CITY OF ALBUQUERQUE

May 28, 2015

**RE: National Electric, 2200 Midtown Plaza NE
Grading and Drainage Plan
Engineer's Stamp Dated 5-06-15 (File: G16-D095E)**

GRADING AND DRAINAGE PLAN

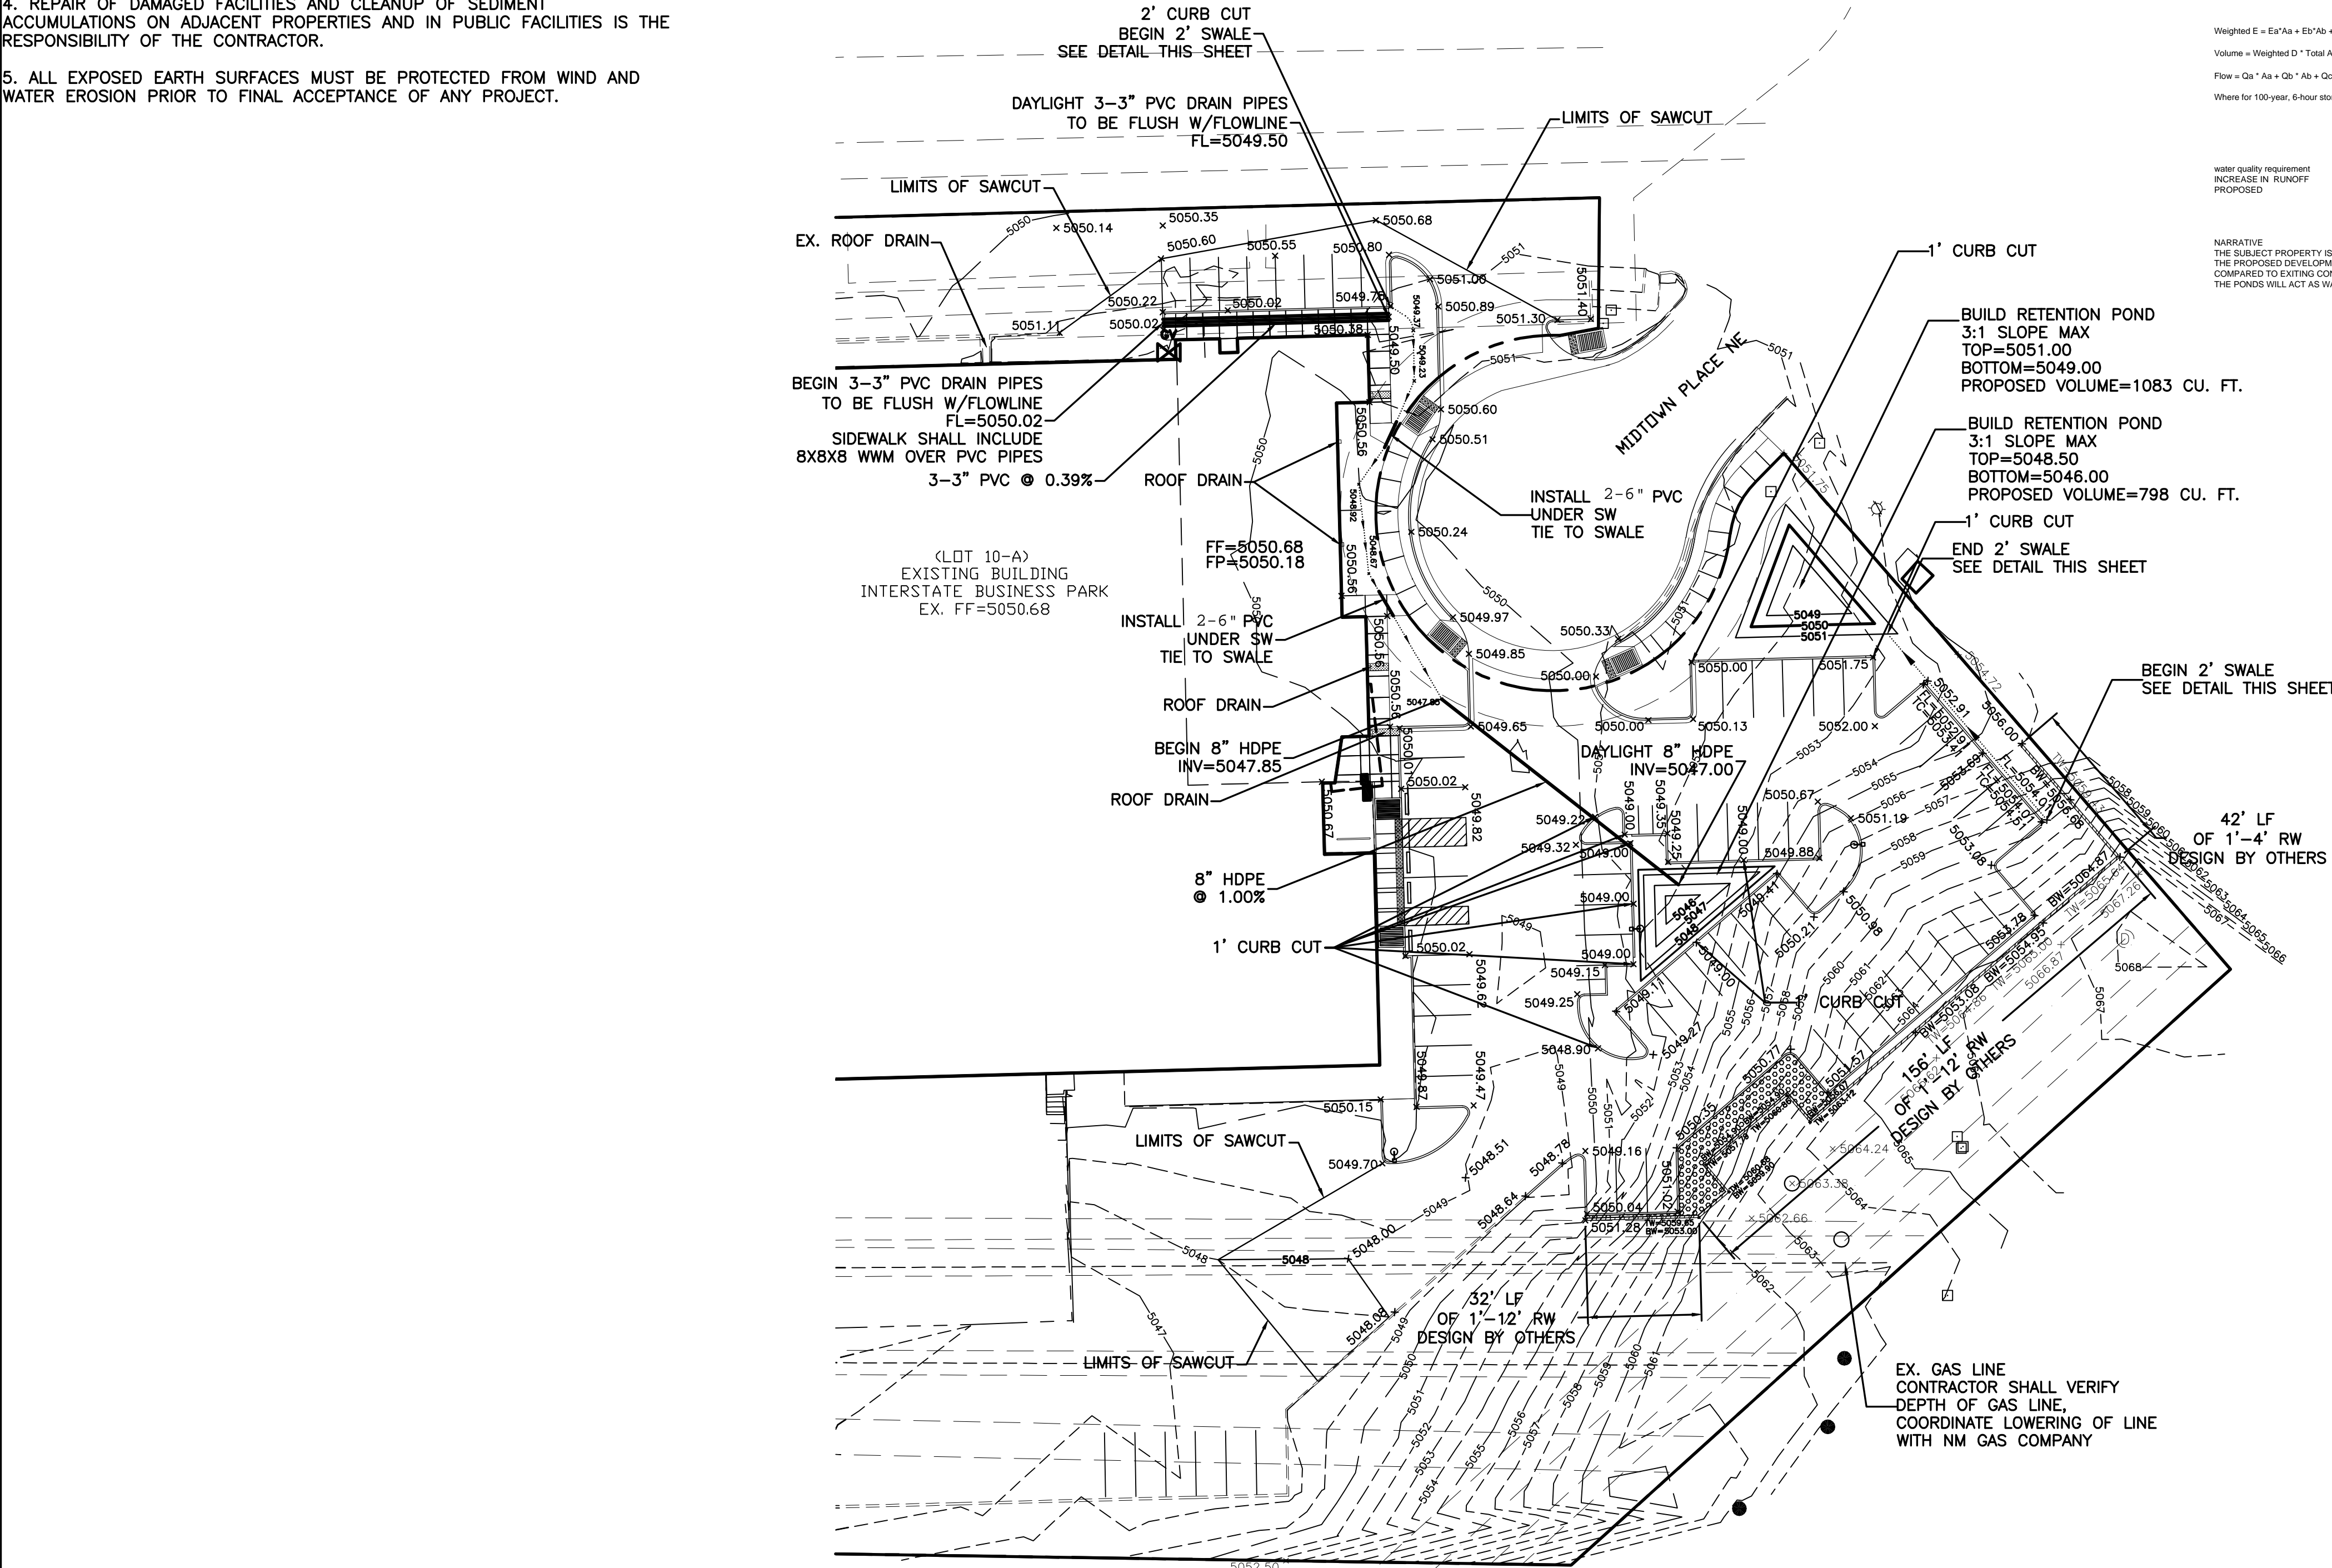
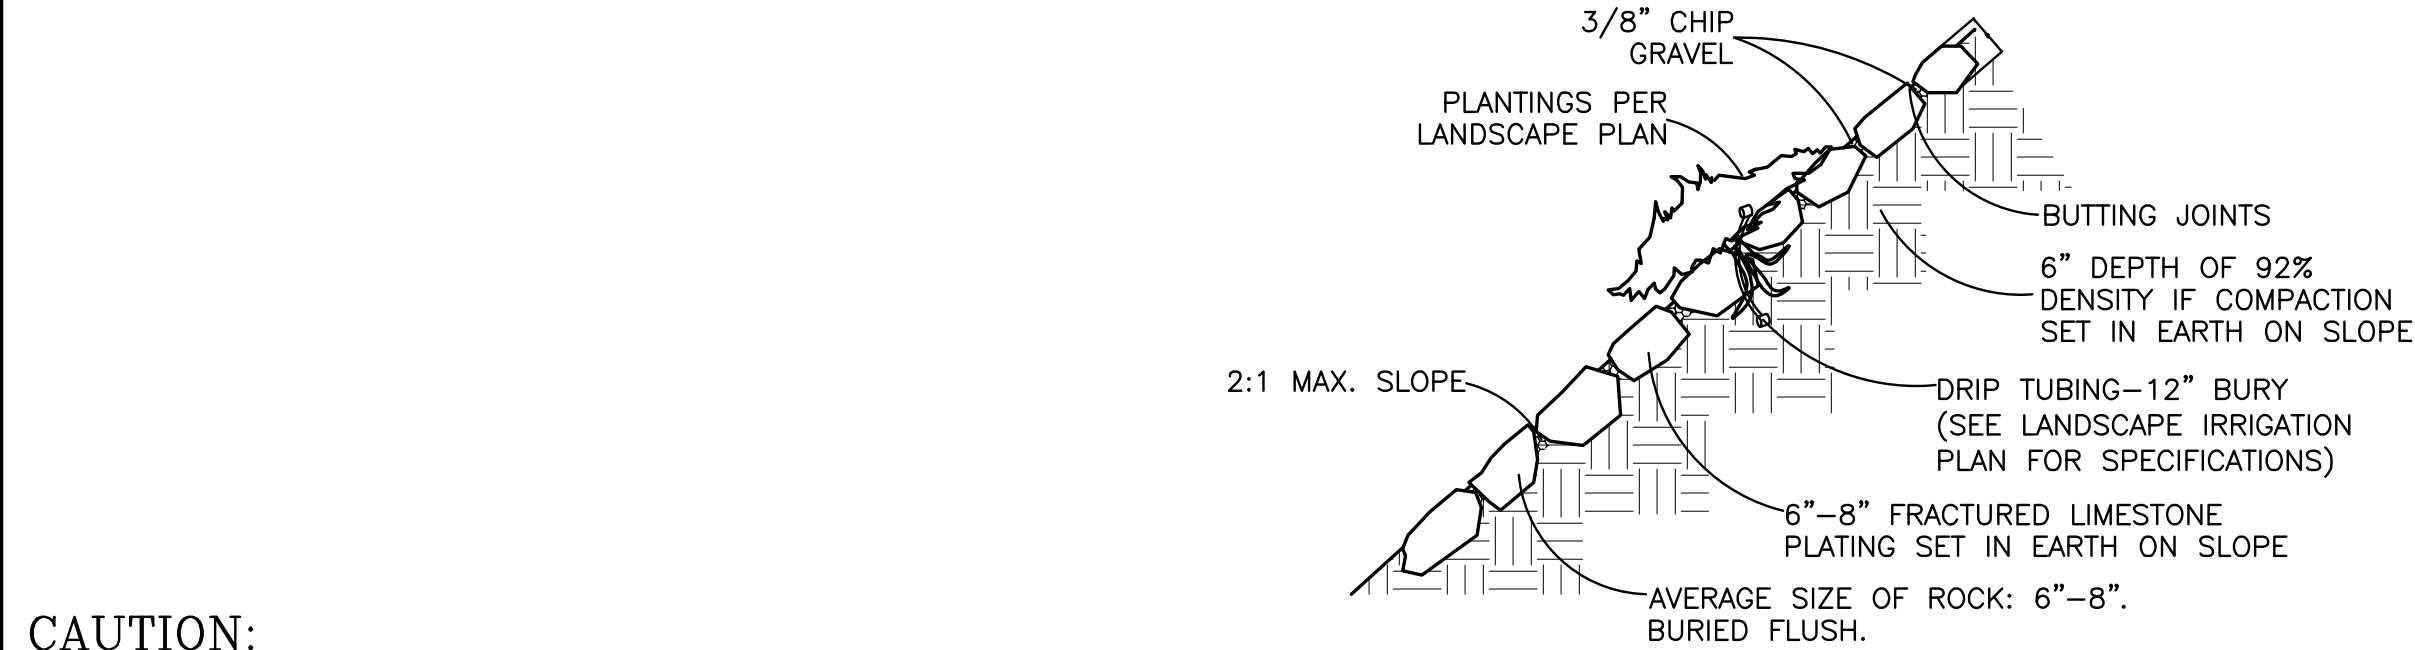
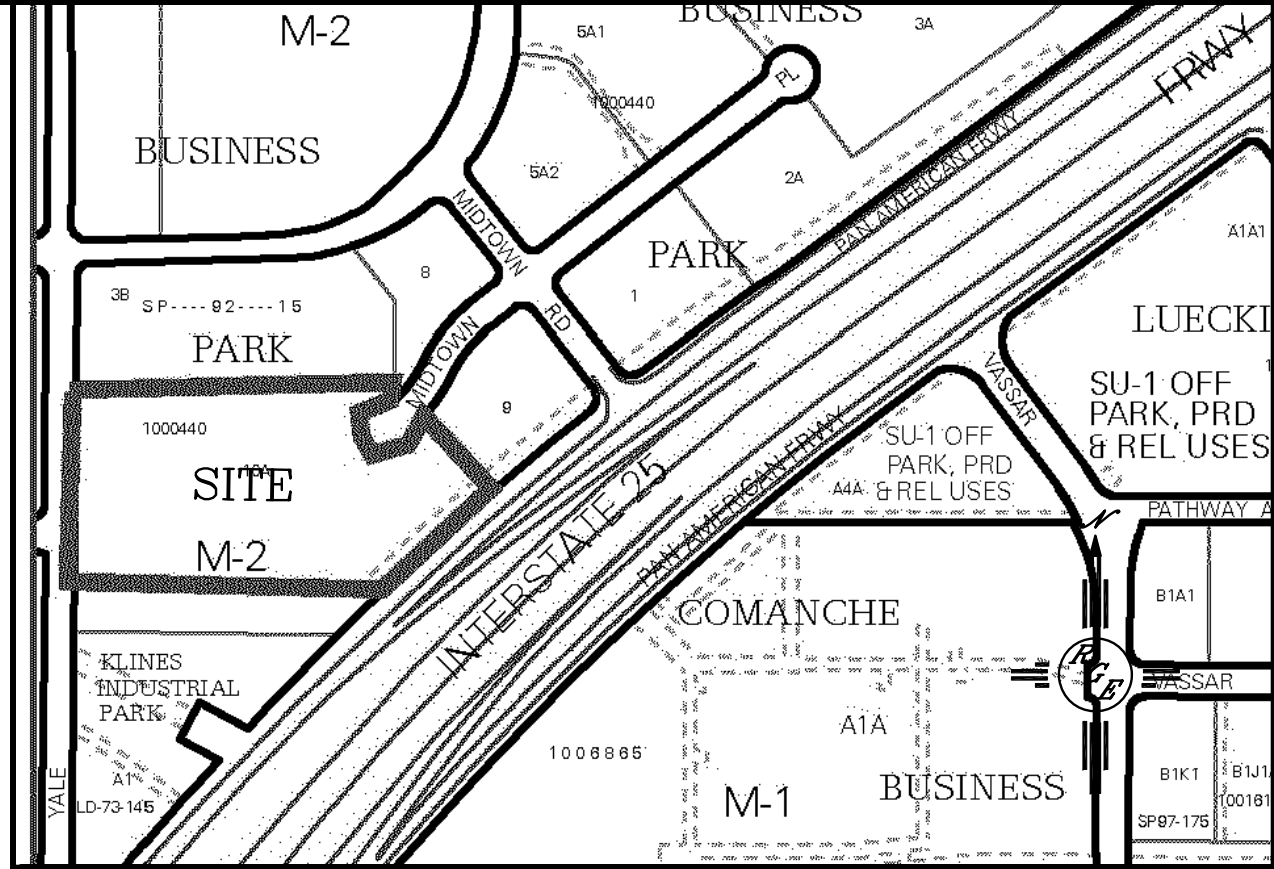
- 1) Show basin boundaries for the provided basin computations, and show where new improvements end and tie into existing facilities.
- 2) Label existing contours and the new contours for the ponds.
- 3) Show swale from 5049.85 spot elevation at entryway to the pond on the north side of the site.
- 4) Show existing and new roof drains.
- 5) In the "Drainage Narrative", mention overall acreage of the site, and explain that historical flow patterns for the site remain the same if this is the case. Discuss the off-site flows from Midtown Place that the site is accepting, and reference the prior drainage report. Mention that the new retention ponds retain the volume of increased runoff from existing conditions.
- 6) Label 100-year storm flow that each of the new on-site pipes is conveying and the pipe slope. Demonstrate capacities.
